## REQUEST

Approximately 7.7 acres located on Tennyson Drive near Interstate 85.

The petition proposes to allow 38 single family attached residential dwelling units on a vacant site in the Enderly Park neighborhood.

RZ-2

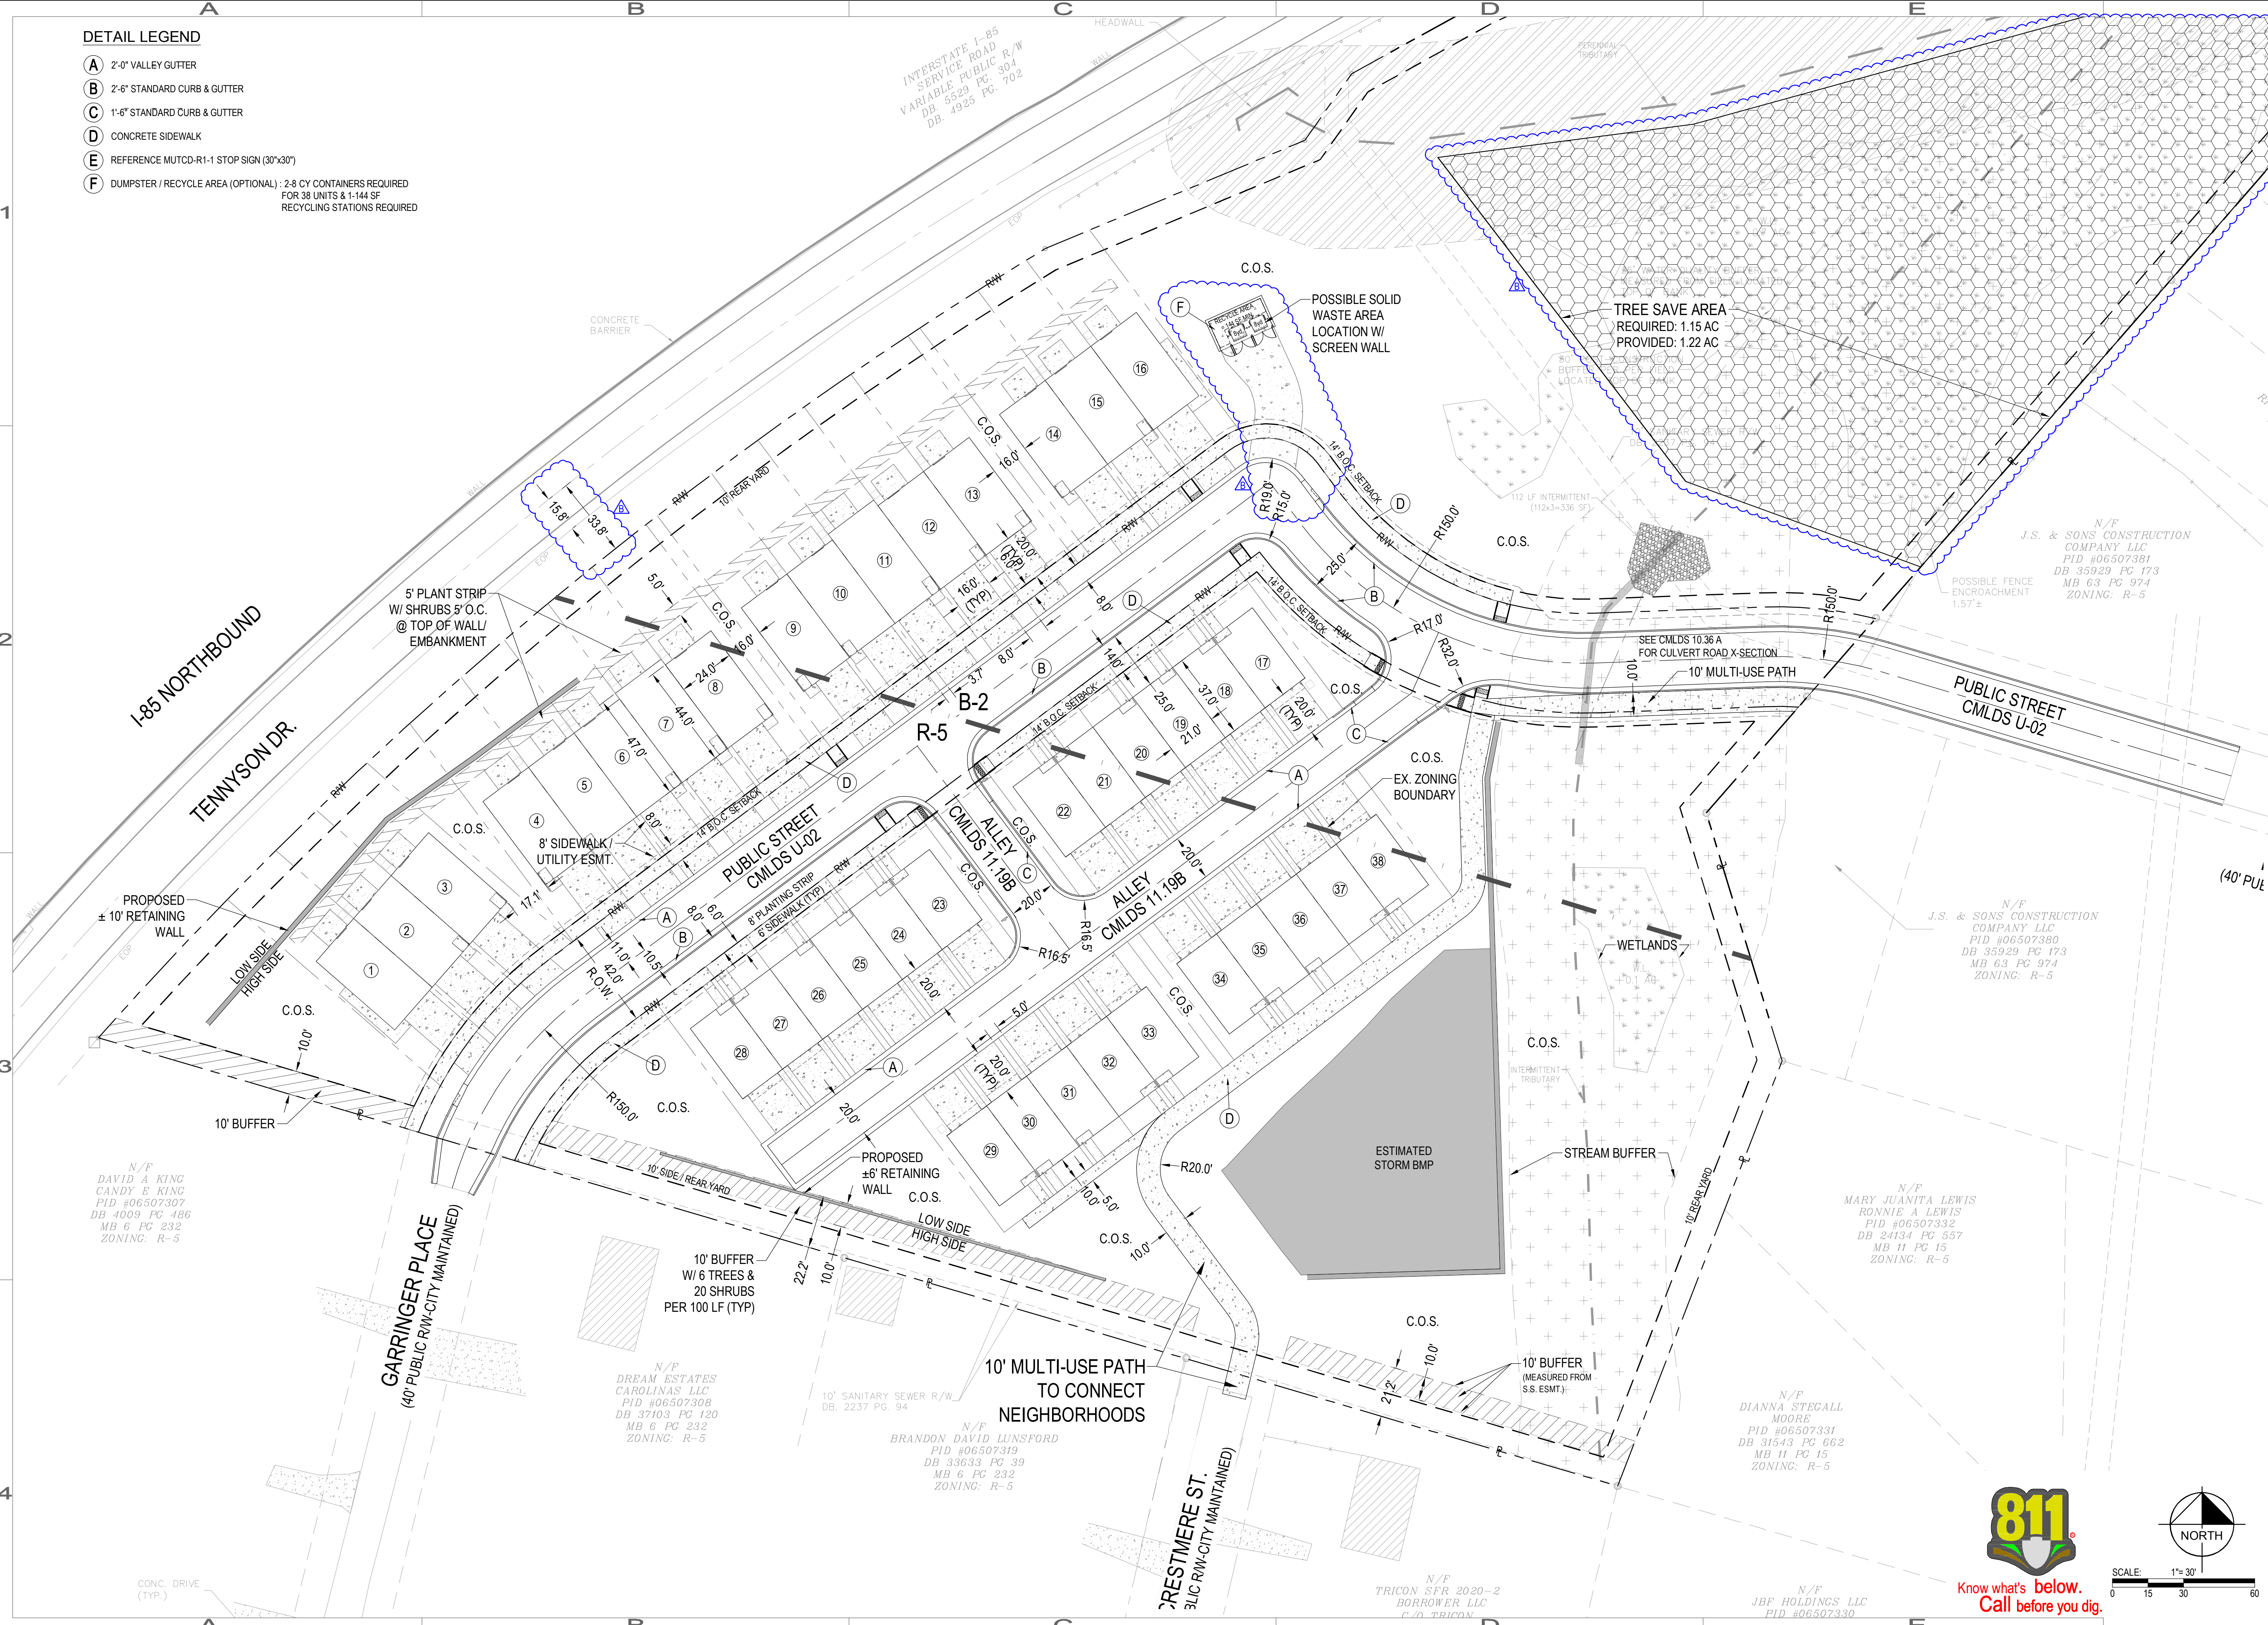
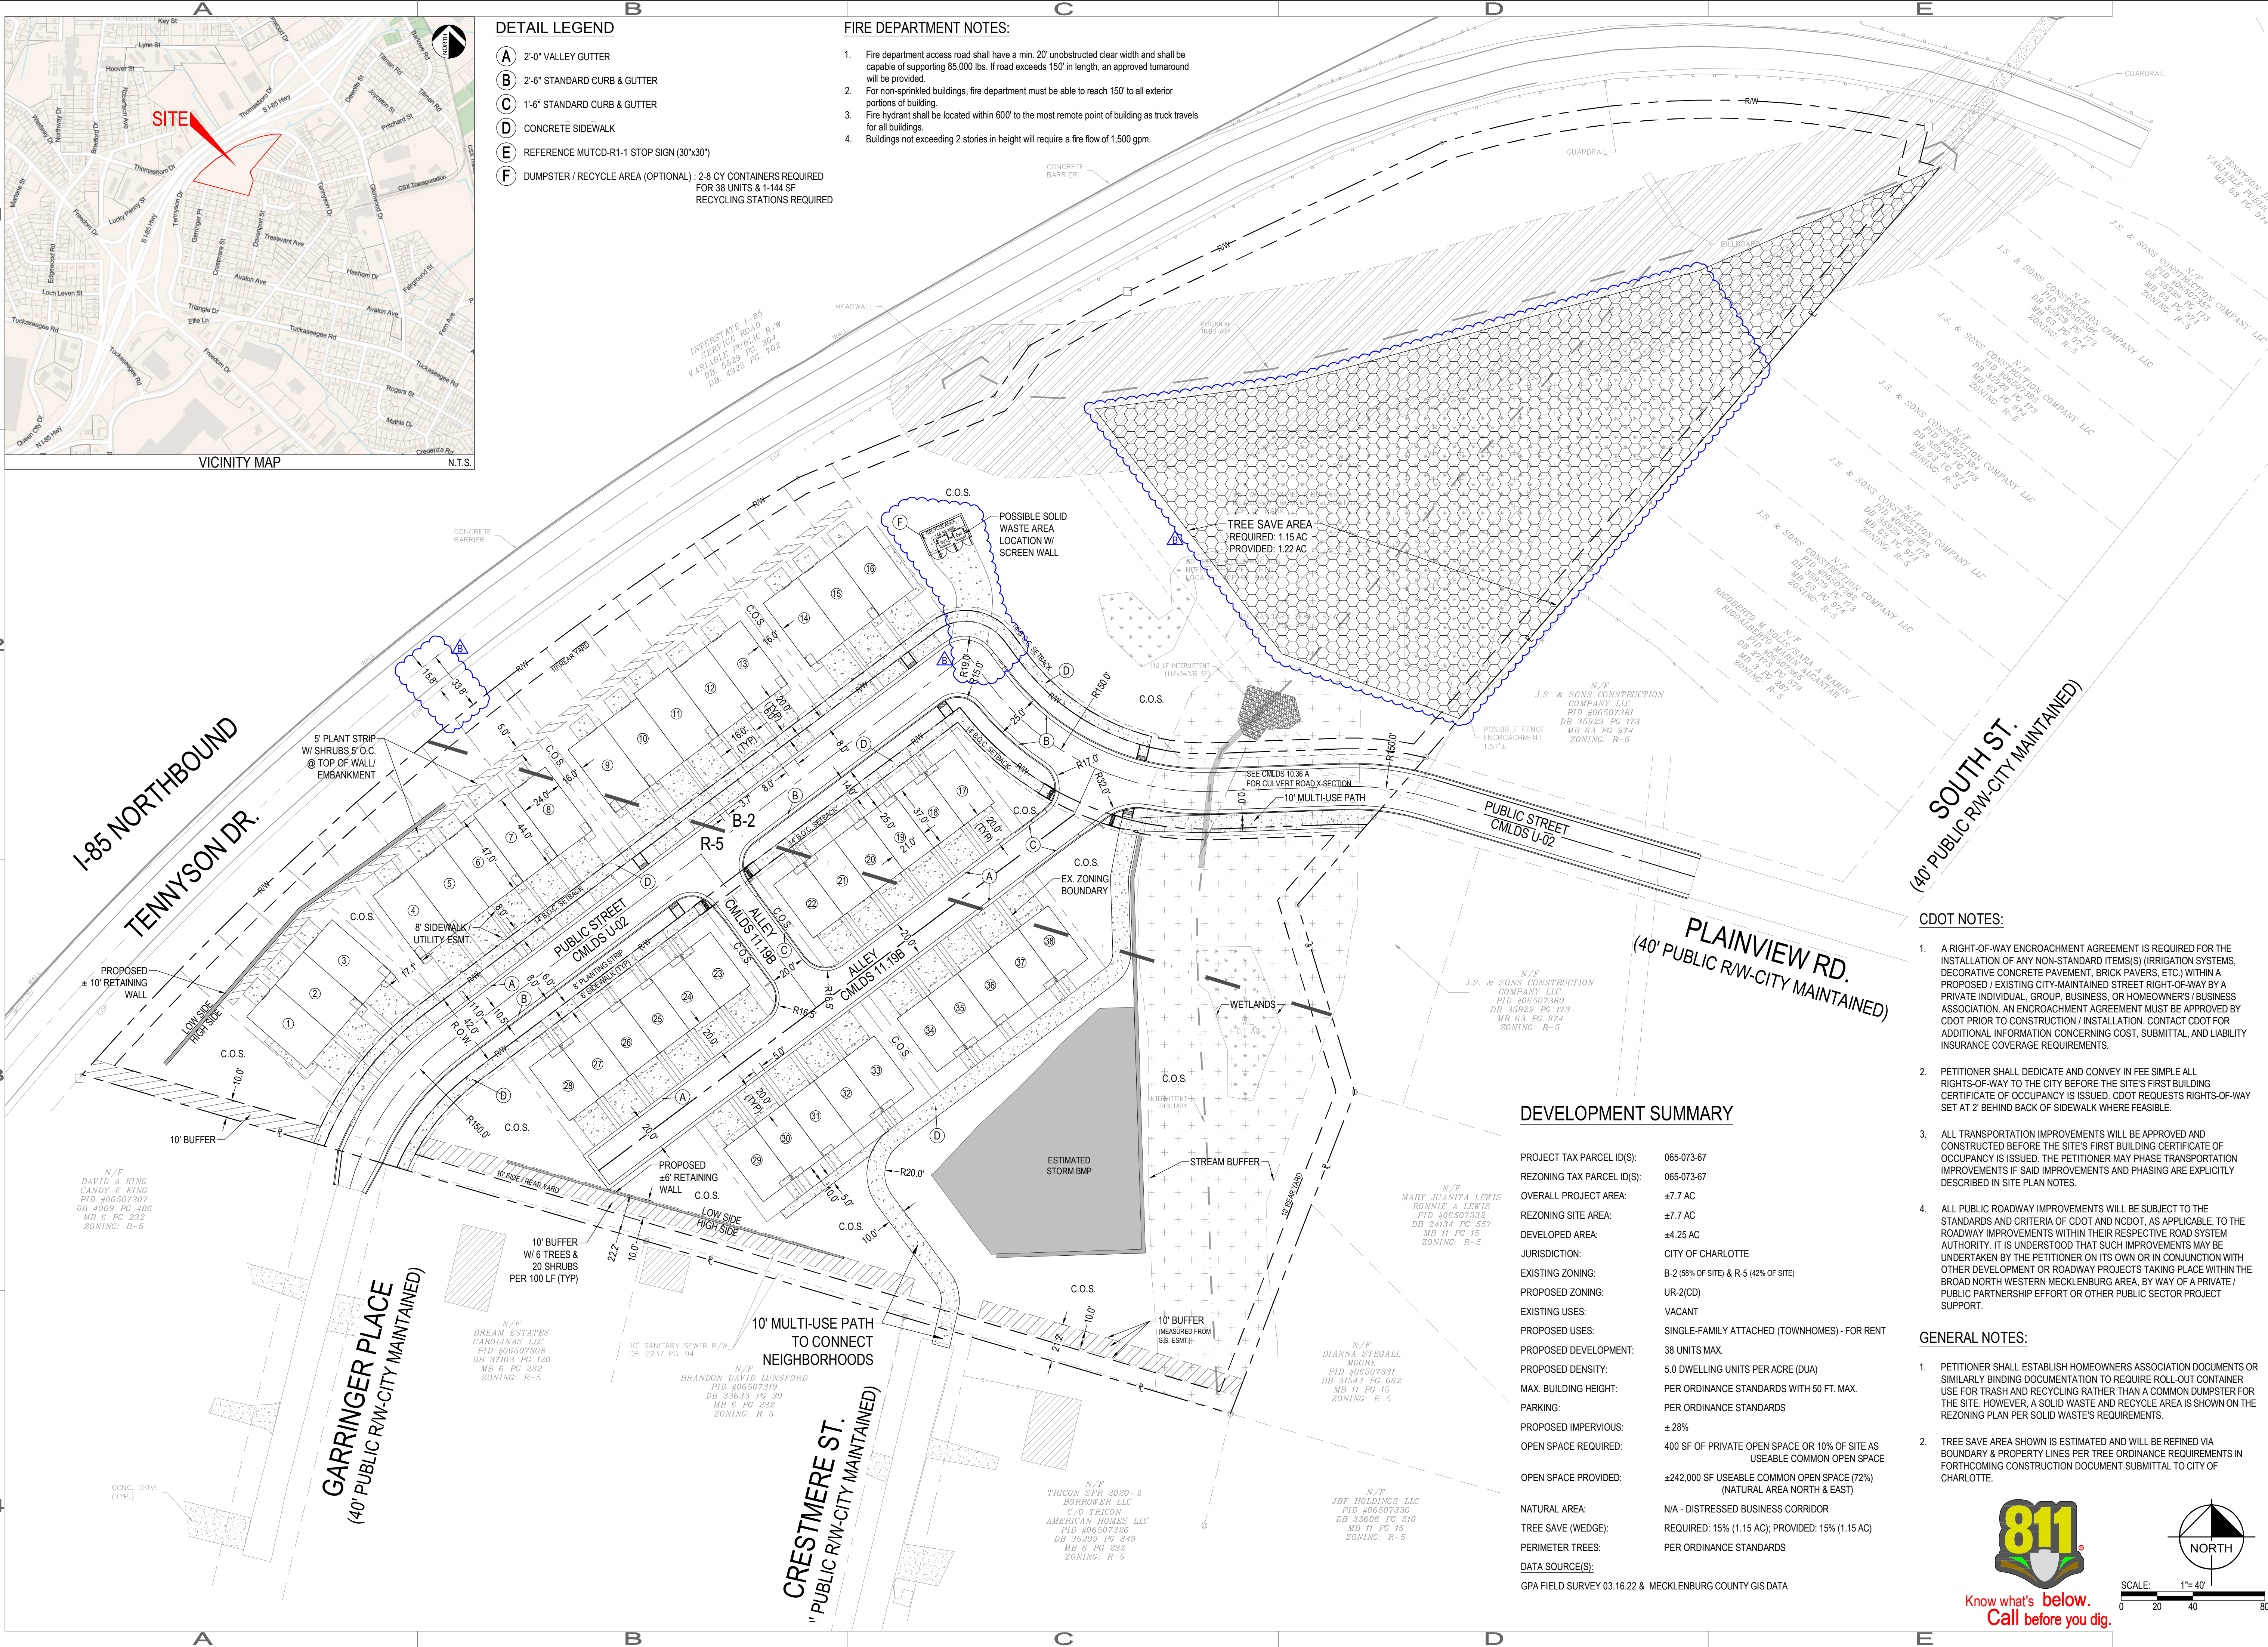
1. Add "AIR" to both the existing and proposed zoning on site plan. This site is within the Airport Noise Overlay, abbreviated as "AIR".

2. Revise roadway design to remove 90 degree turn and satisfy CDOT standards for public roadway geometry.
